Recommendation Report for Planning Permission for Works or Extension to a Dwelling

REF NO: LU/6/26/HH

LOCATION: 71 Fastnet Way
Littlehampton
BN17 6RZ

PROPOSAL: Two storey side extension.

71 FASTNET WAY, LITTLEHAMPTON
Proposals 04
Dec 2025

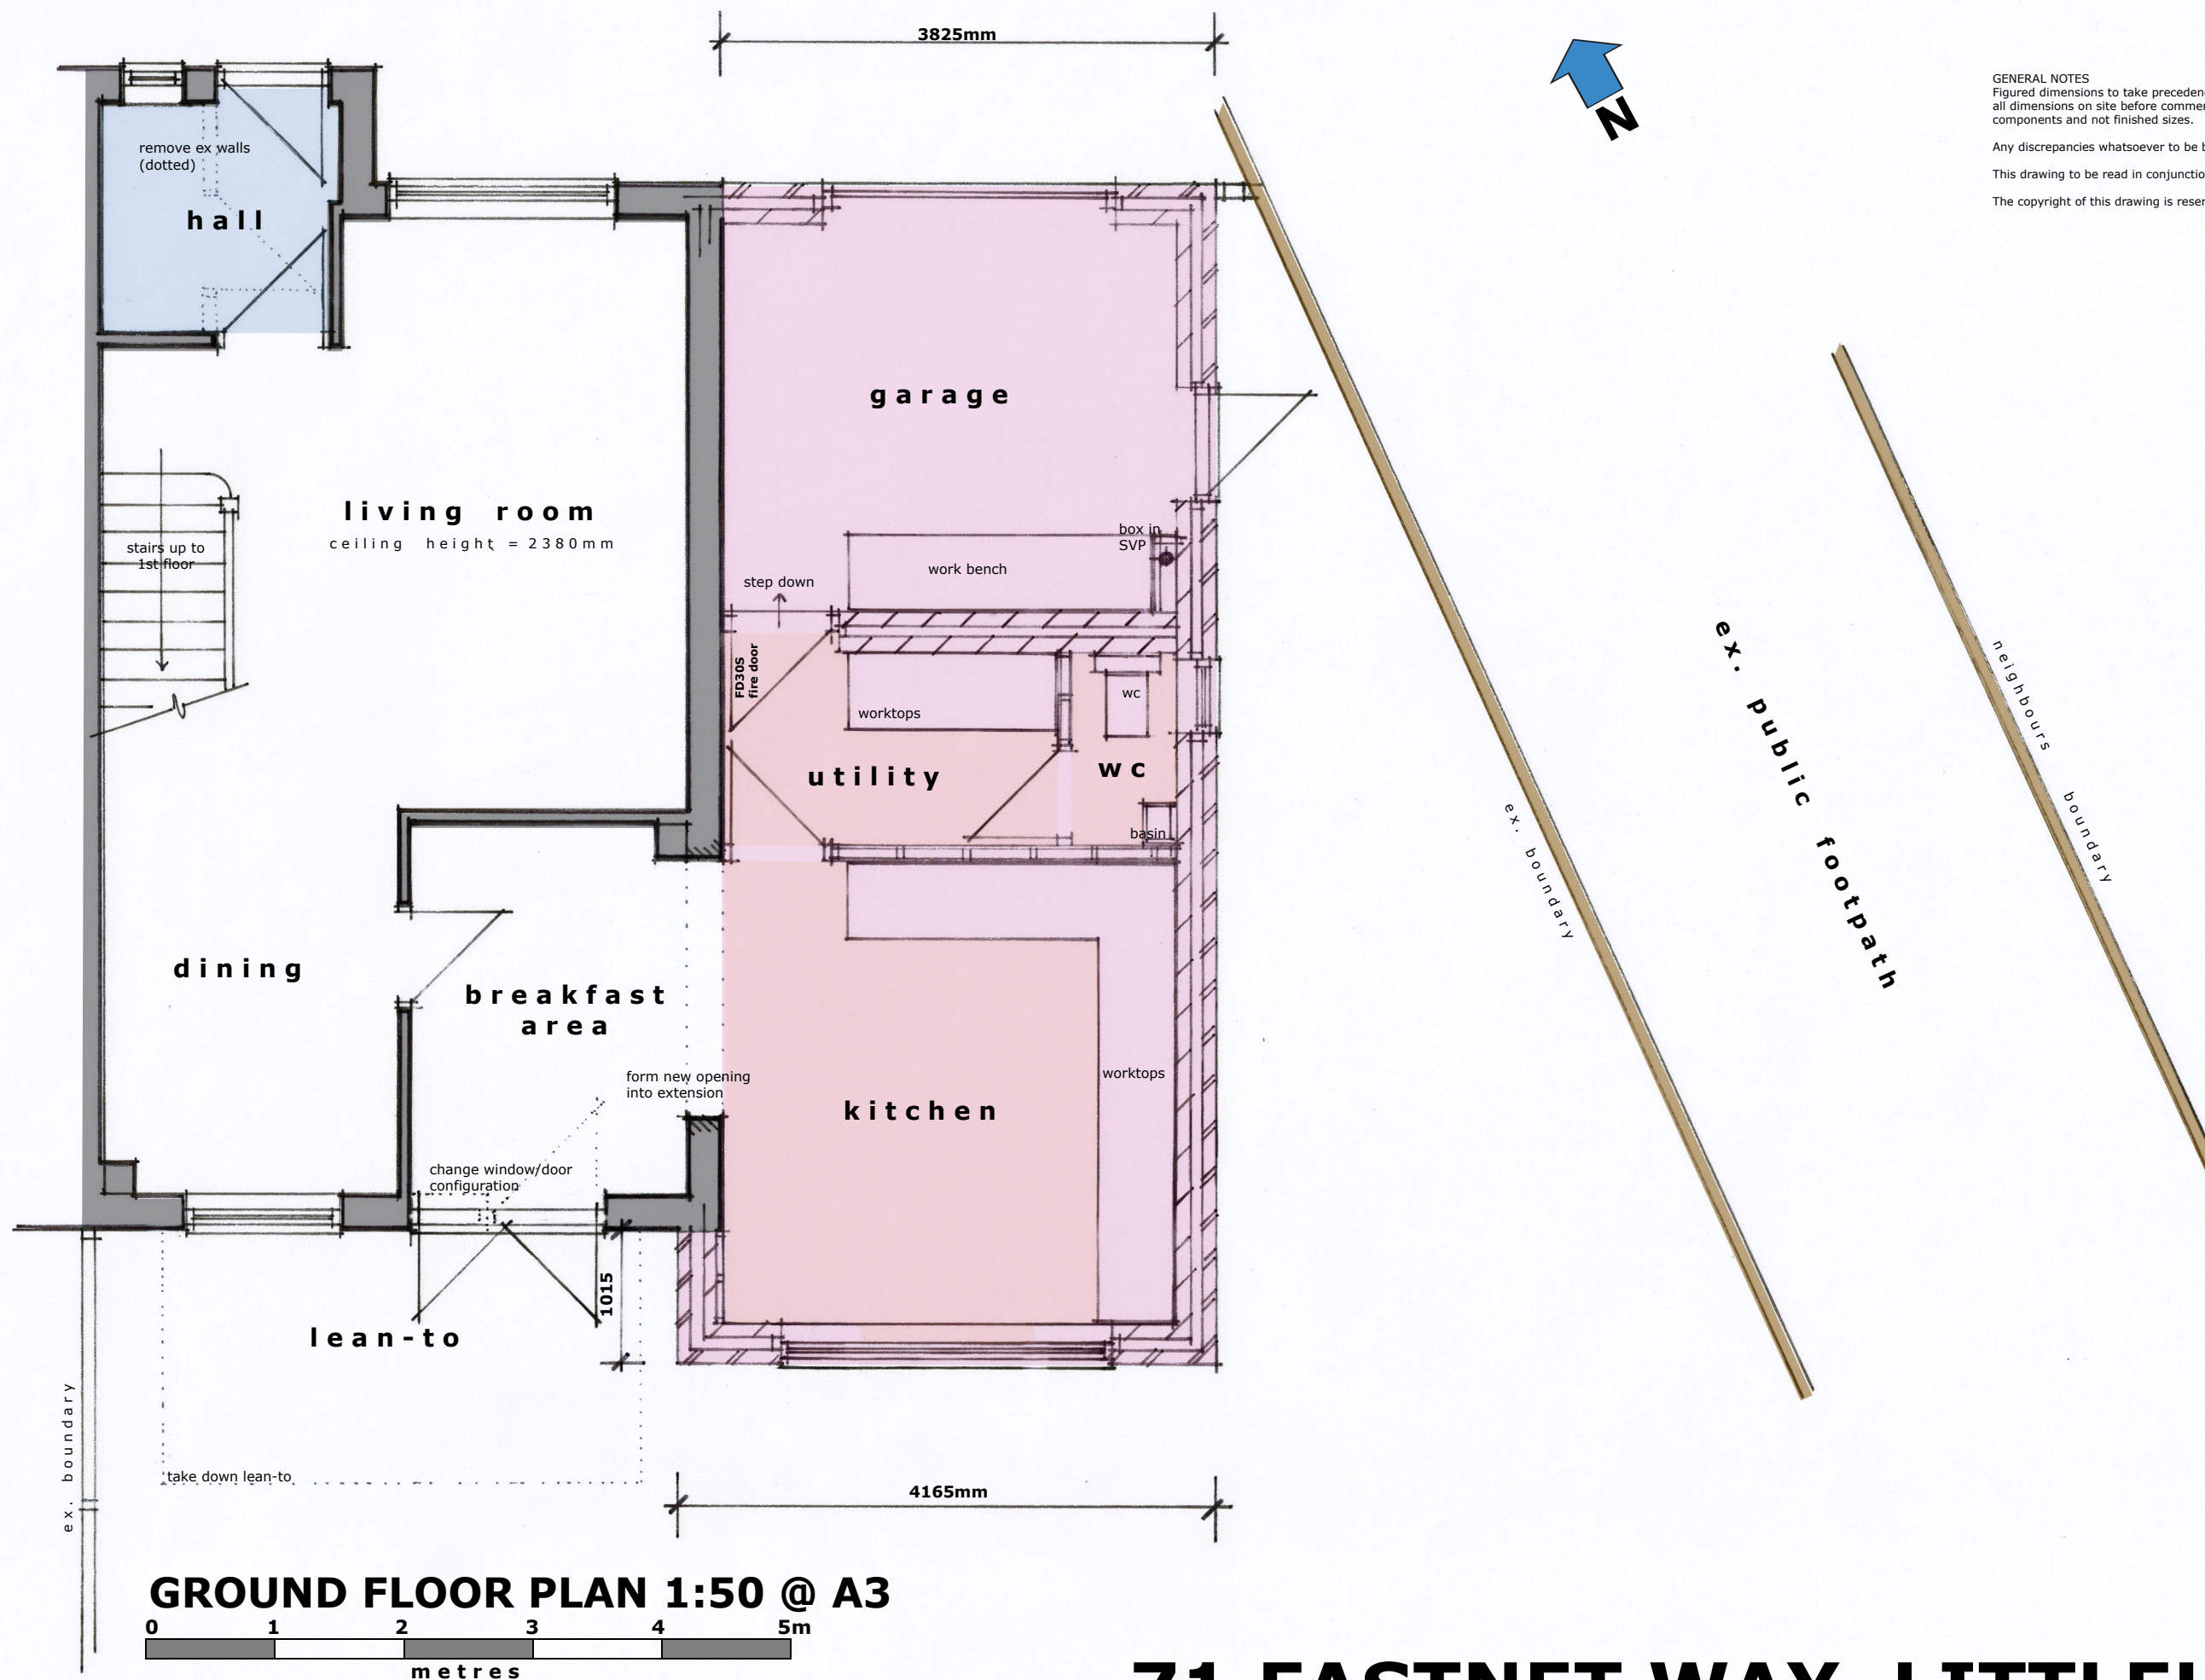
The proposal is for a two storey side extension to the eastern flank of the host dwelling. The extension would measure approximately 3.8m in width and 9.2m in depth. It would also incorporate a single storey rear extension, extending approximately 1m beyond the existing rear elevation, with a width of 4.2m to the rear. The extension would feature a pitched roof with a maximum height of approximately 8m and an eaves height of around 5m, both of which would align with those of the existing dwelling.

The proposed extension would be set in approximately 7.4m from the neighbouring dwelling to the east. The extension would not extend beyond the existing rear elevation of this neighbour, however the extension would extend forward from this neighbour. Notwithstanding this, an acceptable separation distance between the extension and the neighbour to the east would be maintained, further reinforced by the presence of a public footpath and an existing 1.8m high boundary fence. The proposed extension would not result any overbearing, or overshadowing impacts on the neighbour to the east.

The application site is located within Parking Zone 2 and as per the Arun Parking Standards (APS), 4 bedroom dwellings are required to provide 3 parking spaces. It is noted that the proposed garage would not meet the best practice minimum internal dimensions for garages. The ADG states that garages should measure at least 6m by 3m internally to qualify as a parking space. As such, the proposed garage cannot be counted towards the parking provision.

71 FASTNET WAY, LITTLEHAMPTON
Proposals 05

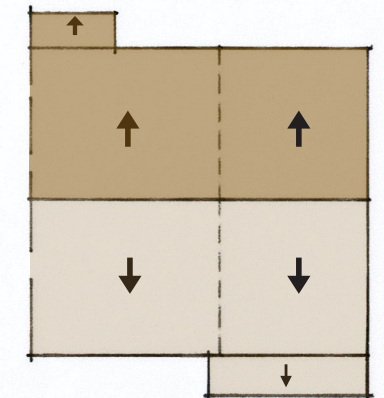
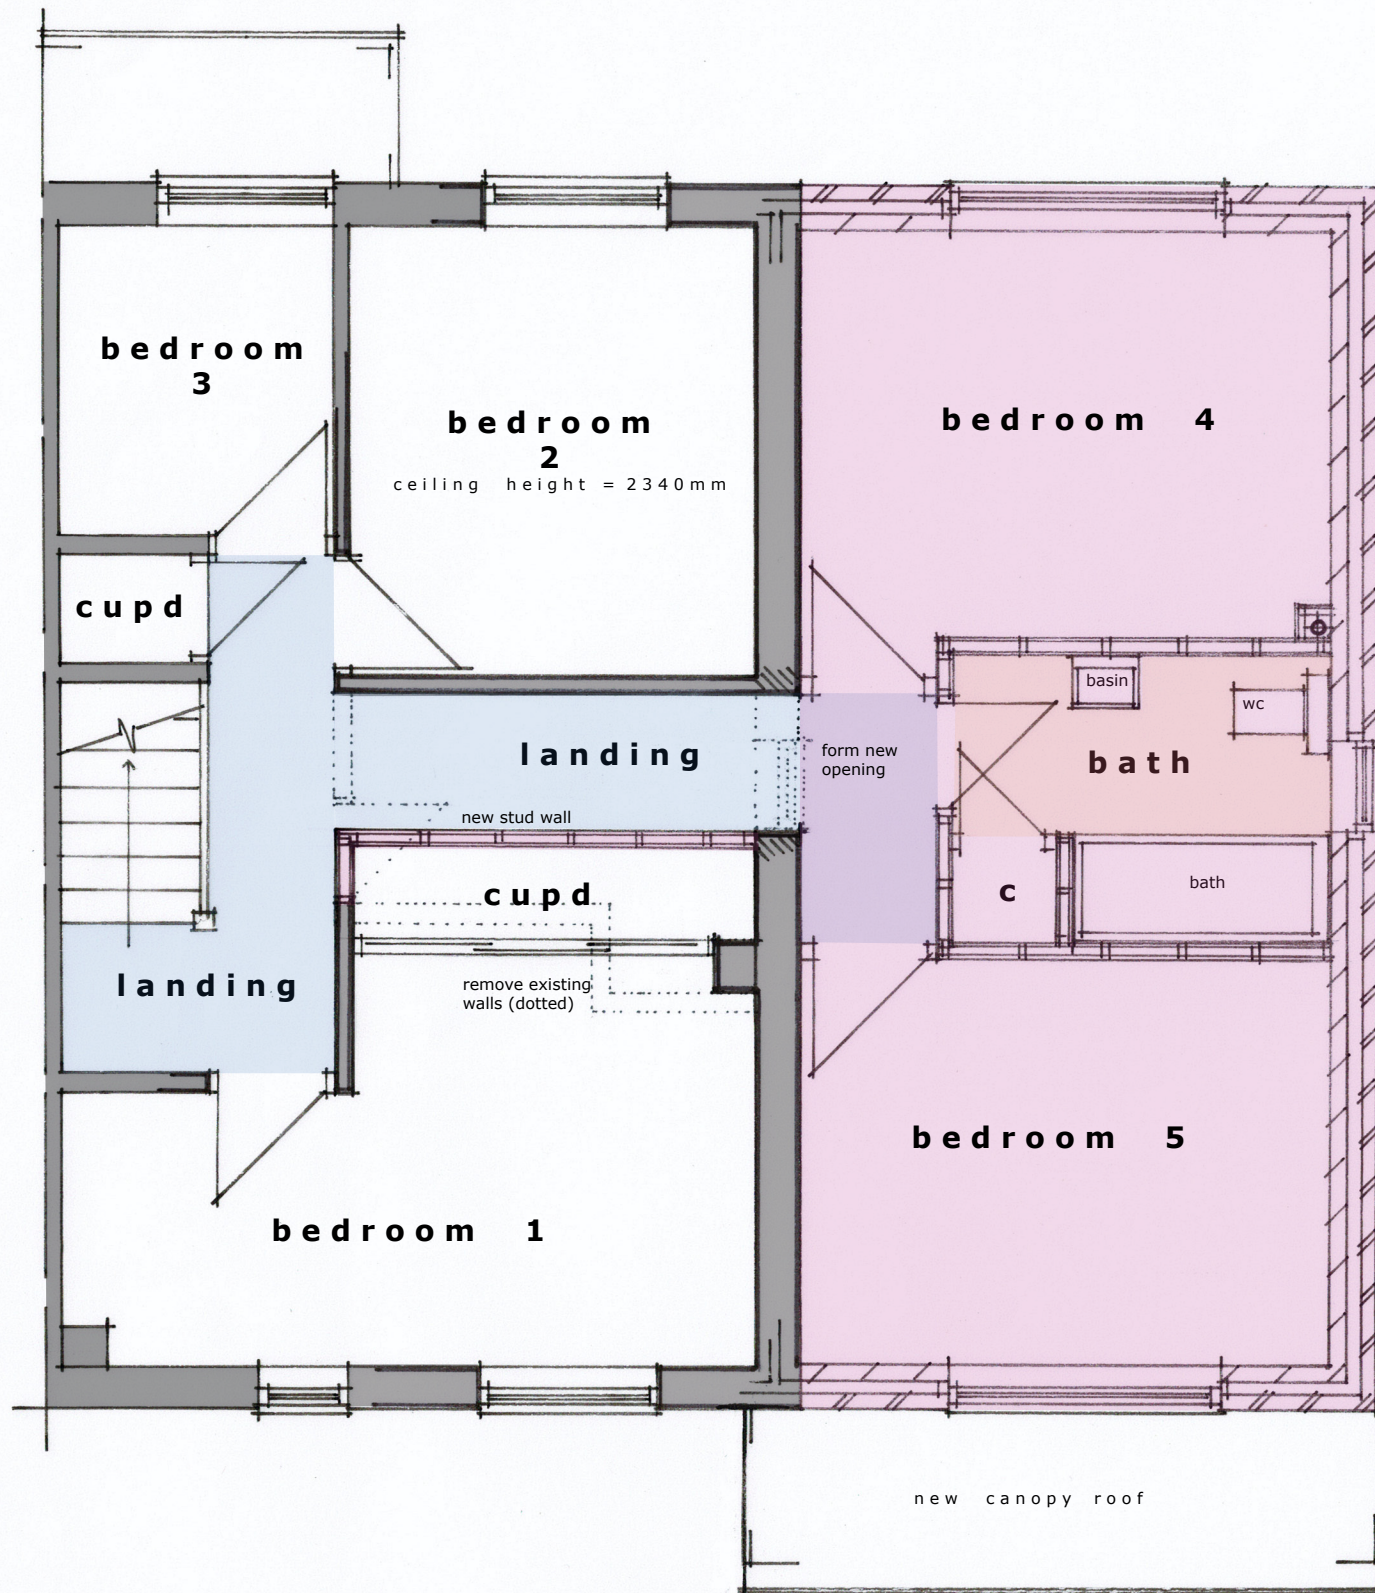
The single storey rear extension would also have a pitched roof form, which would connect to the main extension at first floor level. This design approach would help to integrate the single storey rear extension. External materials would match those of the existing property, incorporating similar brickwork and interlocking roof tiles.

71 FASTNET WAY, LITTLEHAMPTON
Proposals 06
Dec 2025

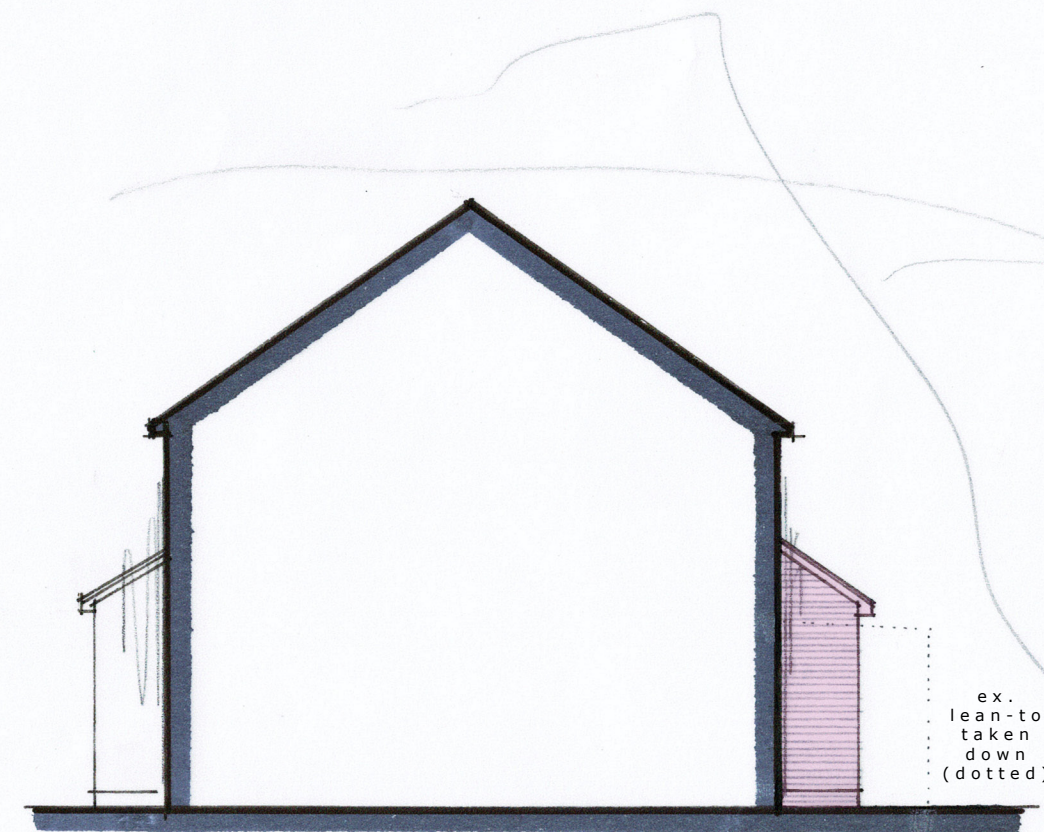
The proposal includes the introduction of a new garage door and a window to the front elevation. On the eastern side elevation, a new entrance door with an adjacent window is proposed at ground floor level, and a window is proposed at first floor level. The rear elevation would contain a first floor window and a larger ground floor opening serving the new extension. All proposed fenestration would be finished in white uPVC to match the existing windows of the dwelling.

The proposed extension would be visible within the street scene and would continue the existing northern building line. While the development would not be set back from the principal elevation and would not be set down from the existing roof ridge, contrary to guidance set out within the Arun Design Guide (ADG) and would not therefore be a subservient addition, the extension would nevertheless integrate with the dwelling. This is due to its use of matching materials, a pitched roof form that reflects the original building, and its overall consistency with the property's existing character.

These openings therefore would not result in any overlooking or loss of privacy to neighbouring properties. Fenestration is proposed within the eastern flank elevation of the extension at ground and first floor levels. The ground floor fenestration would be screened from the neighbour to the east by the existing boundary treatment, and would not result in overlooking. The first floor level window would serve a bathroom, and although closer to the neighbour to the east than the existing flank window, it would remain set a significant distance from this neighbour. Moreover, as the neighbour to the east is set back from the host dwelling, the proposed window would have an outlook over the frontage of this neighbour, and would not result in unacceptable overlooking. The proposed rear fenestration would have an outlook of the rear amenity space serving the host dwelling. Whilst some views of neighbouring gardens would be achievable from the first floor rear fenestration, these views would not be significantly different to those already available from the existing fenestration, and as such, the proposal would not result in unacceptable overlooking.
